CITY OF ALBUQUERQUE

September 22, 2017

RE: **2100 Osuna NE**
Grading Plan Engineer's Stamp Date 8/1/17
Drainage Report Engineer's Stamp Date: 9/1/17
Drainage File: E16D001

NOTES:

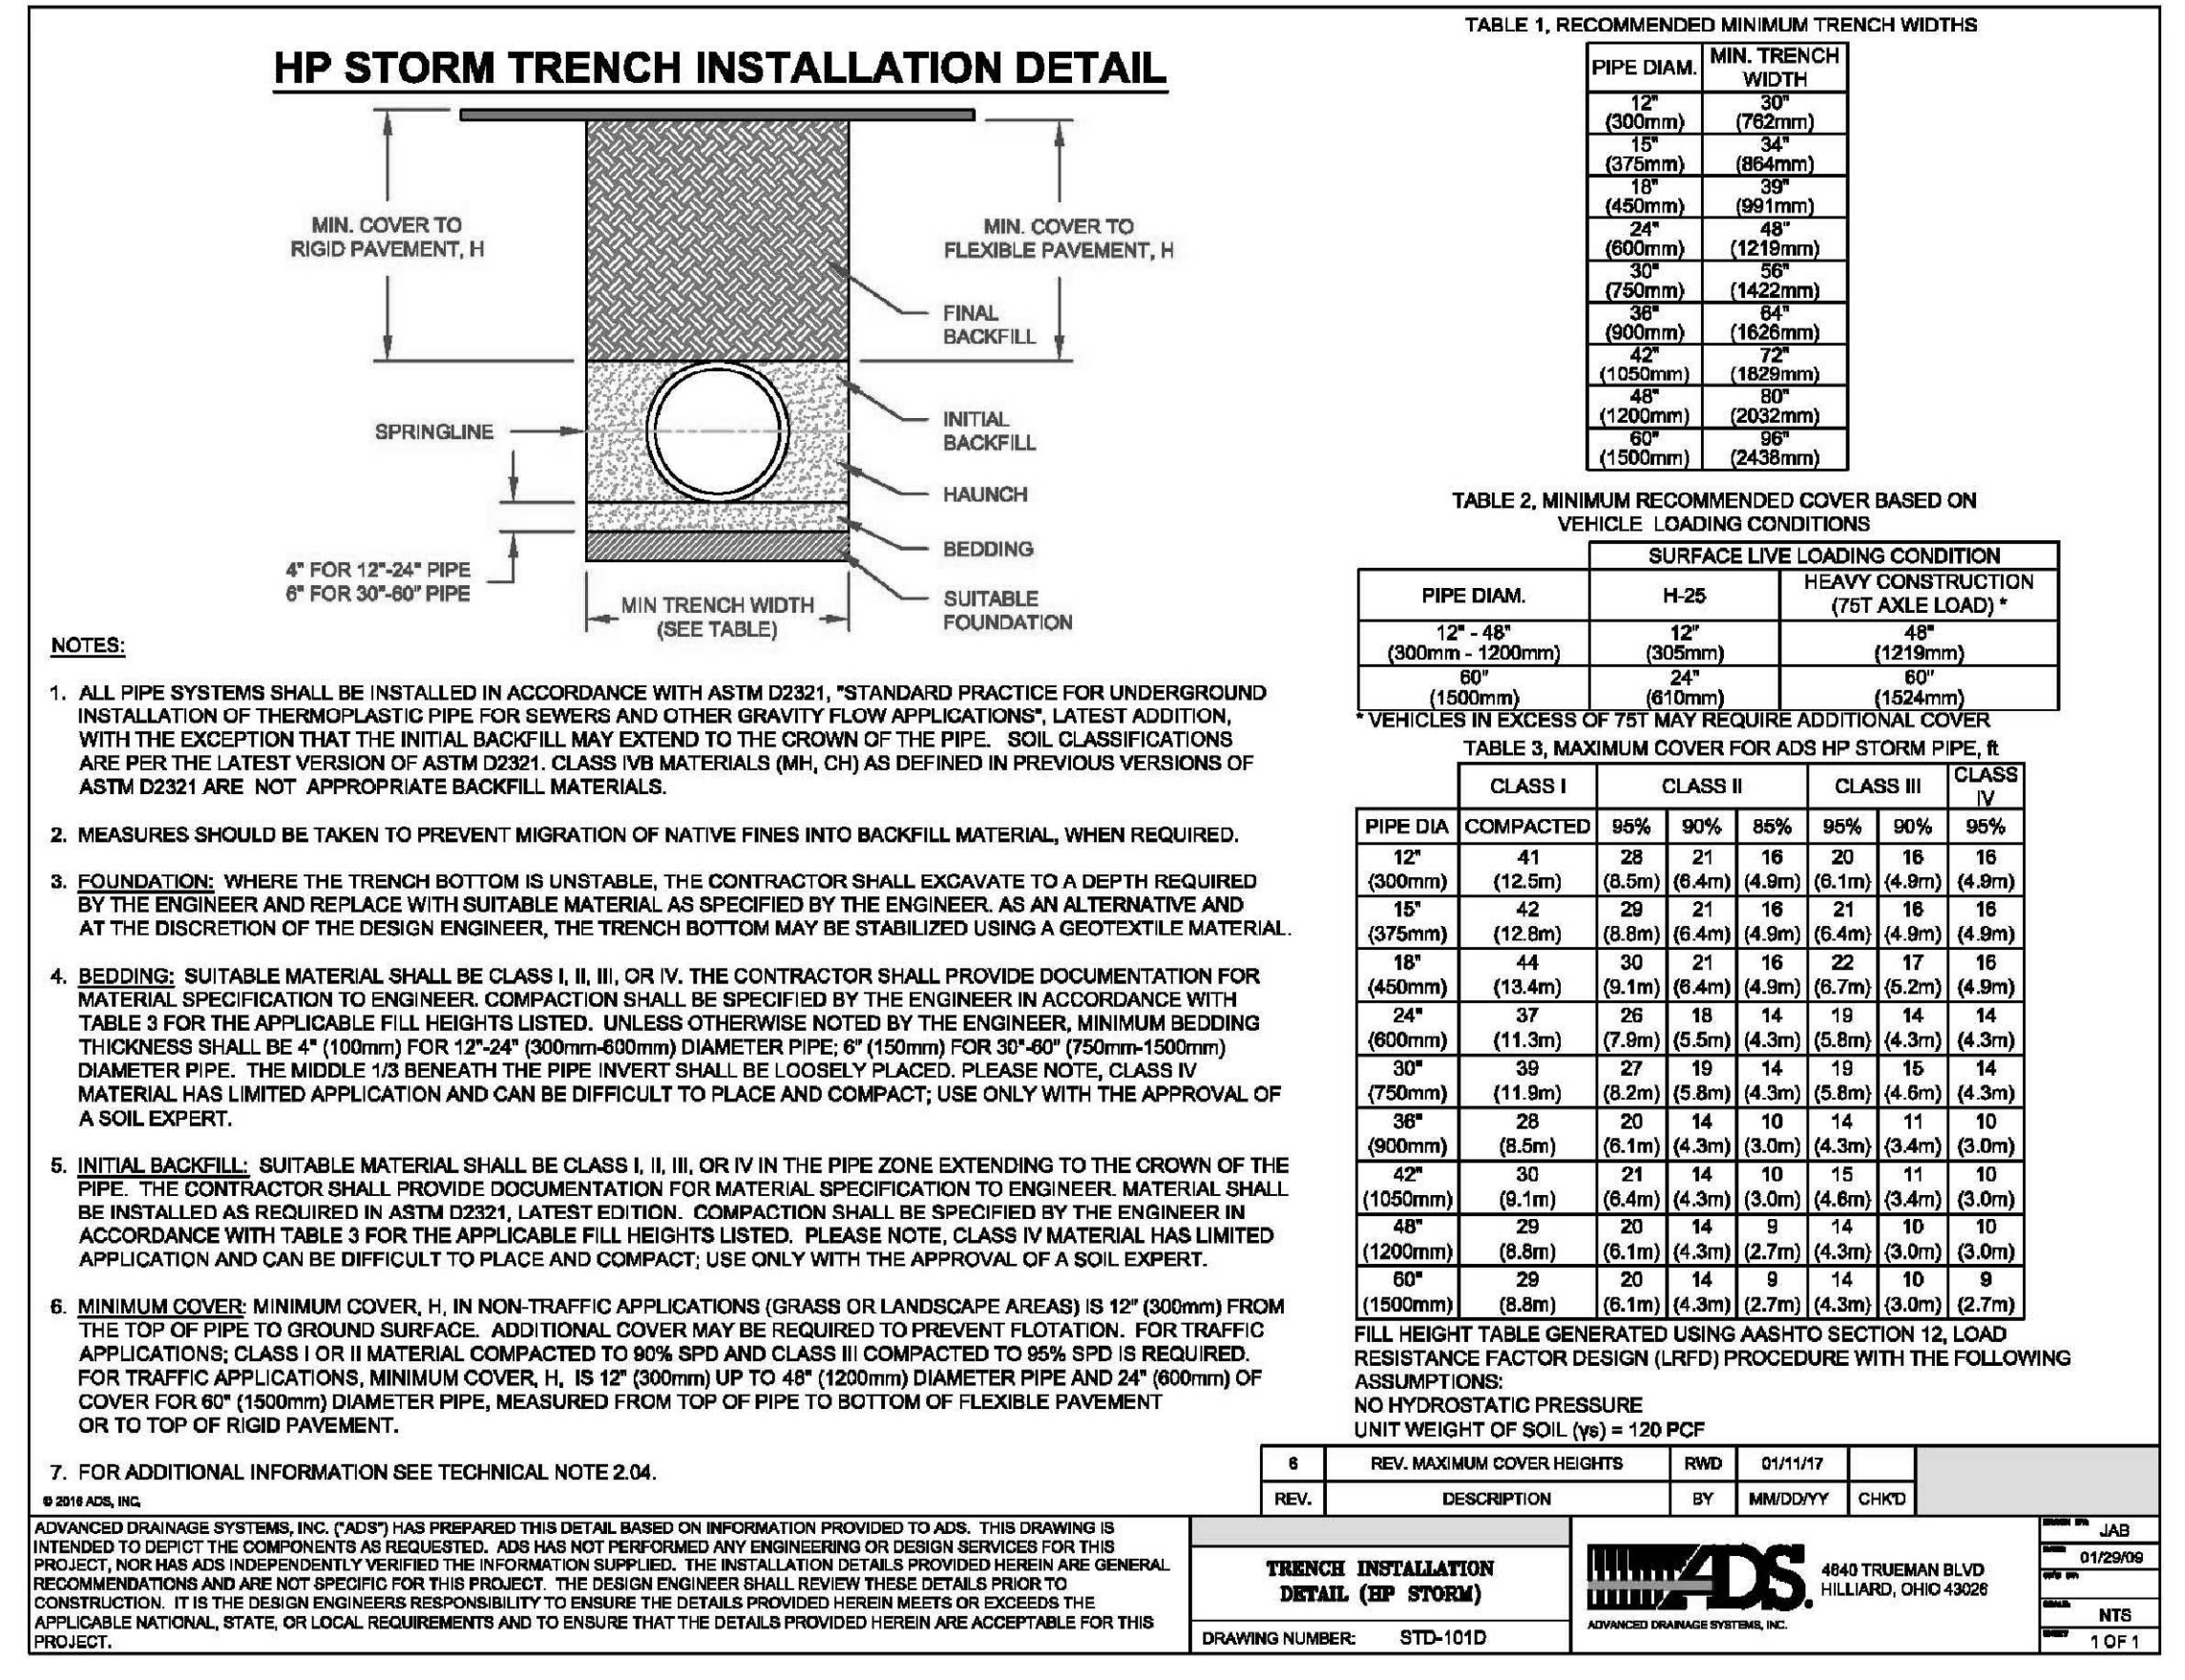
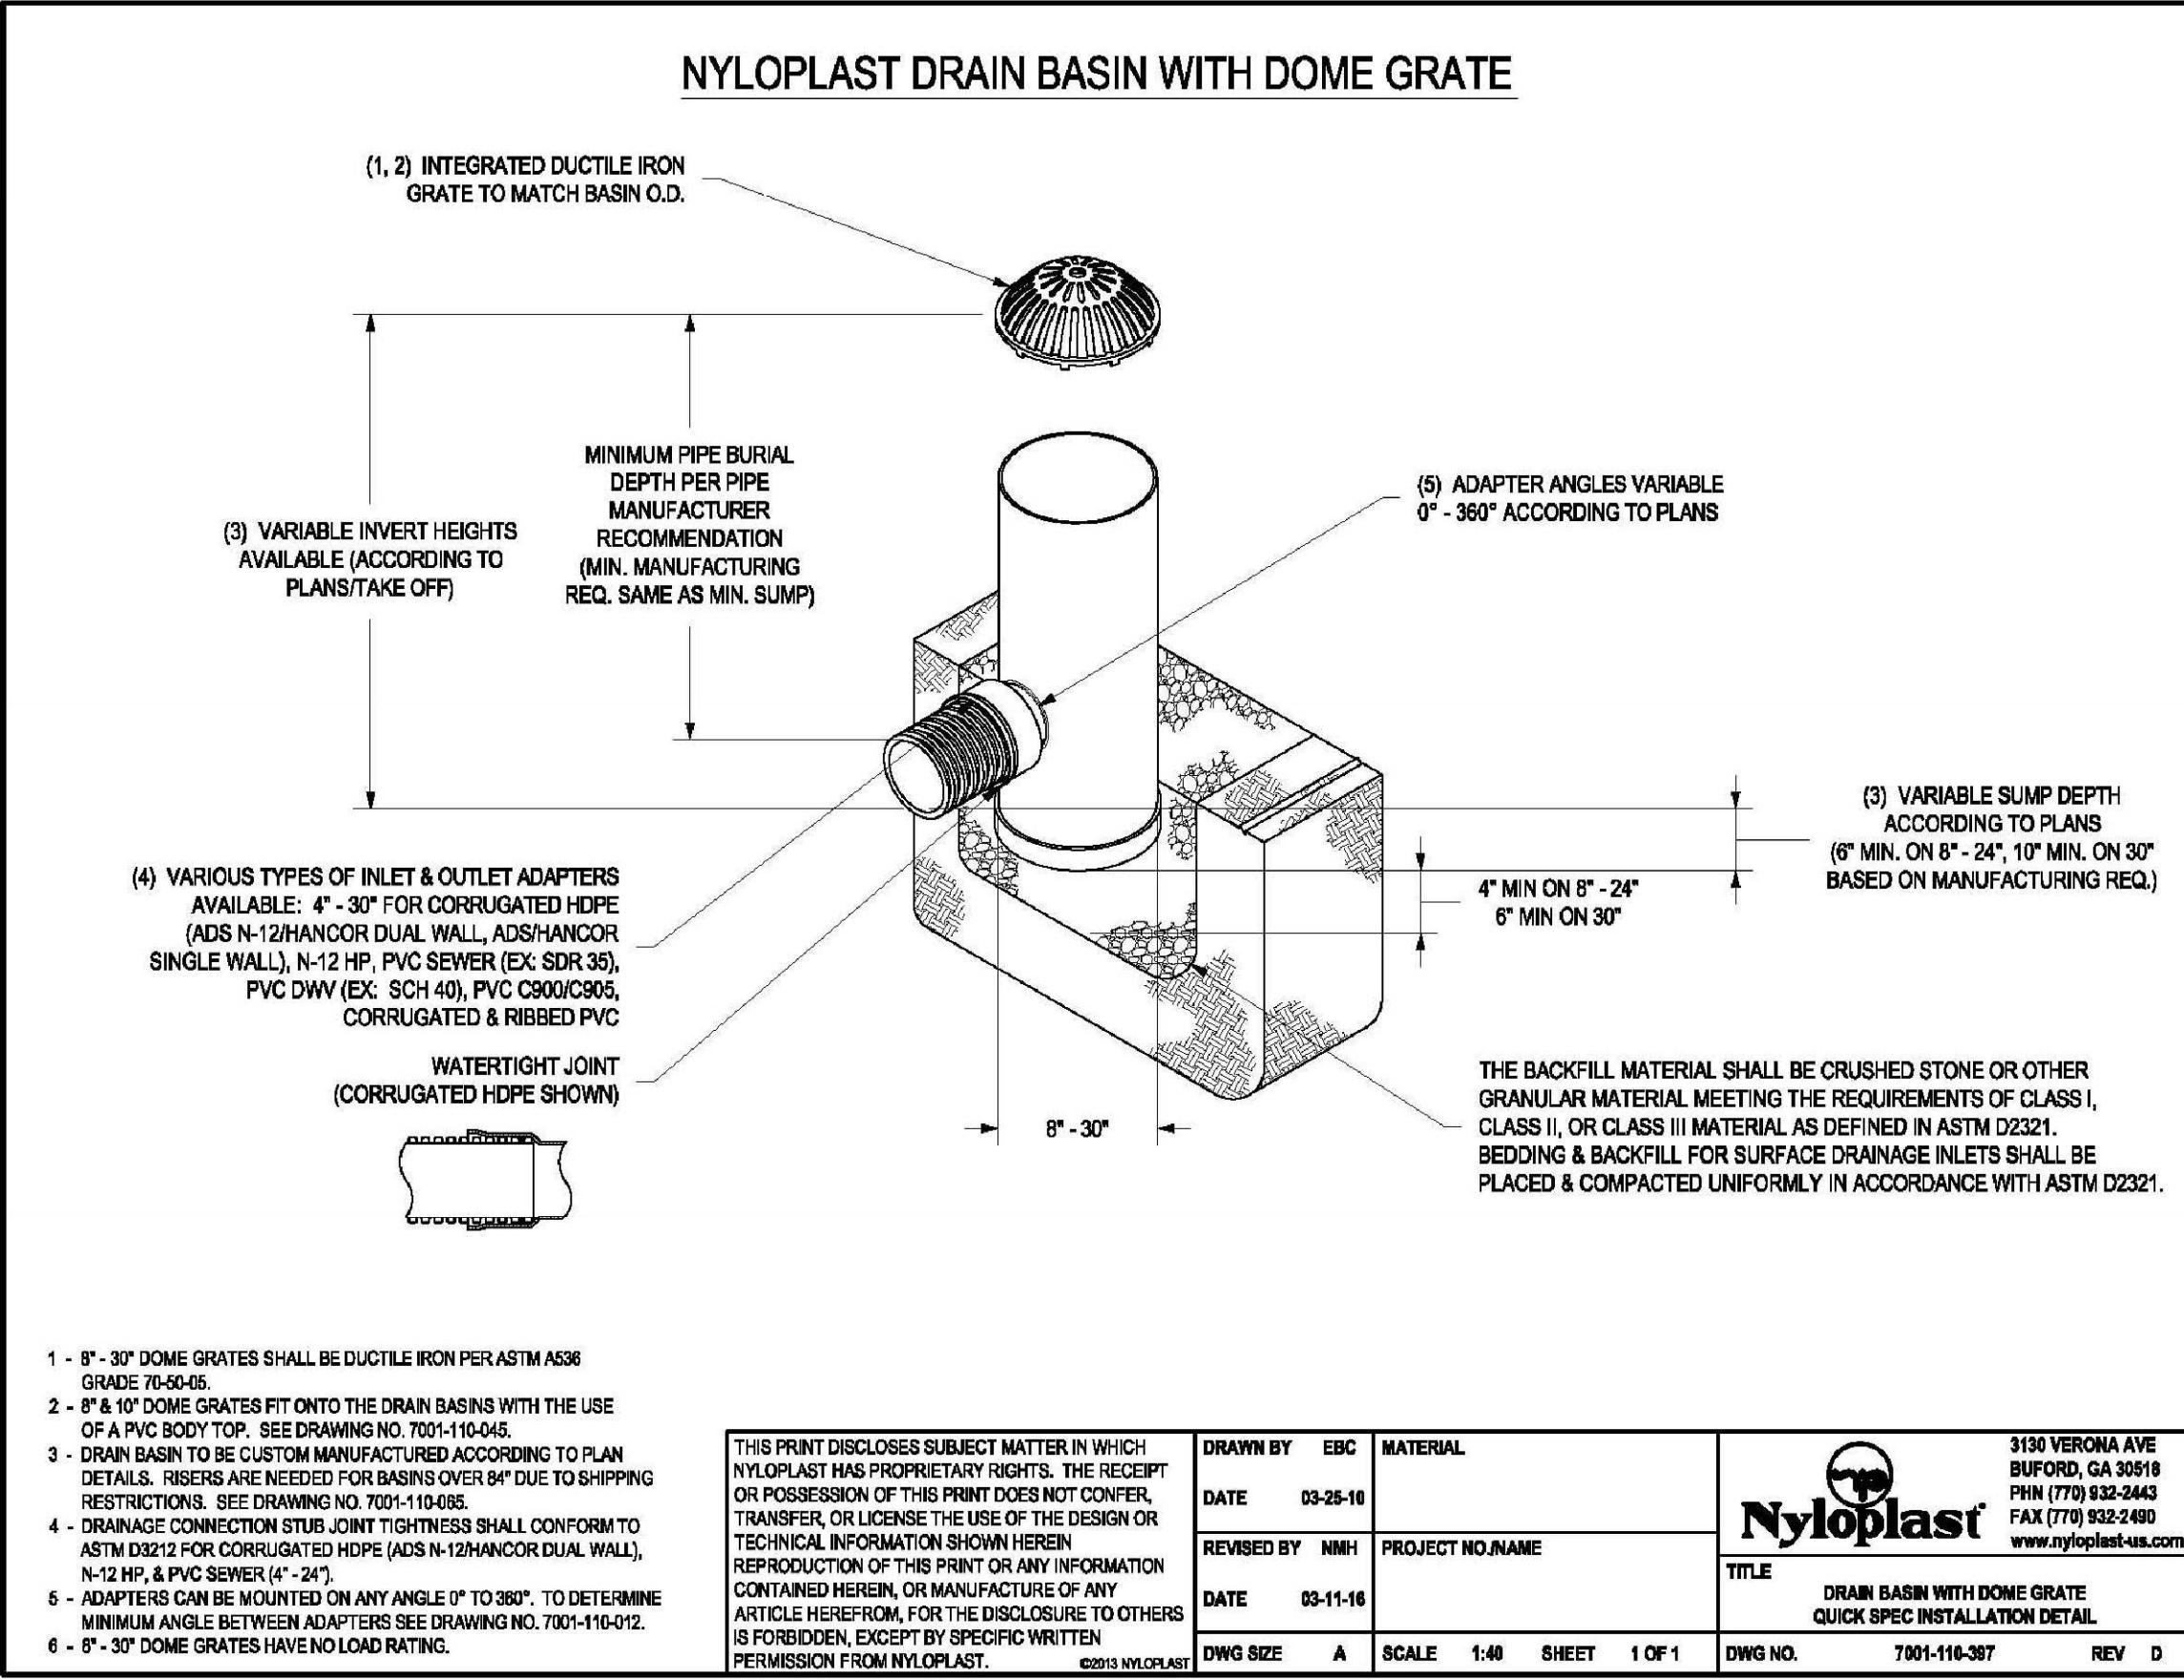
1. Laying the storm drain pipe at a 0.35% slope does not seem constructible; a slope closer to 1% is recommended.
2. Provide a detail for the outlet/reducer/drain grate at the SW pond.
3. Modify the linetype for the existing contours so they stand out from the proposed contours. Add contour labeling to both.
4. Extending existing topo south and west of the SW pond. It is unclear what flows may be entering/existing at this corner.
5. Clearly define the overland flow-path (emergency overflow) from the SW pond to Osuna. Include elevations, dimensions and erosion protection.
6. Provide a section view through the retaining wall.
7. An additional curb cut and grade break at the new entrance appear necessary at the small NW pond to route flows into the pond from the parking lot:
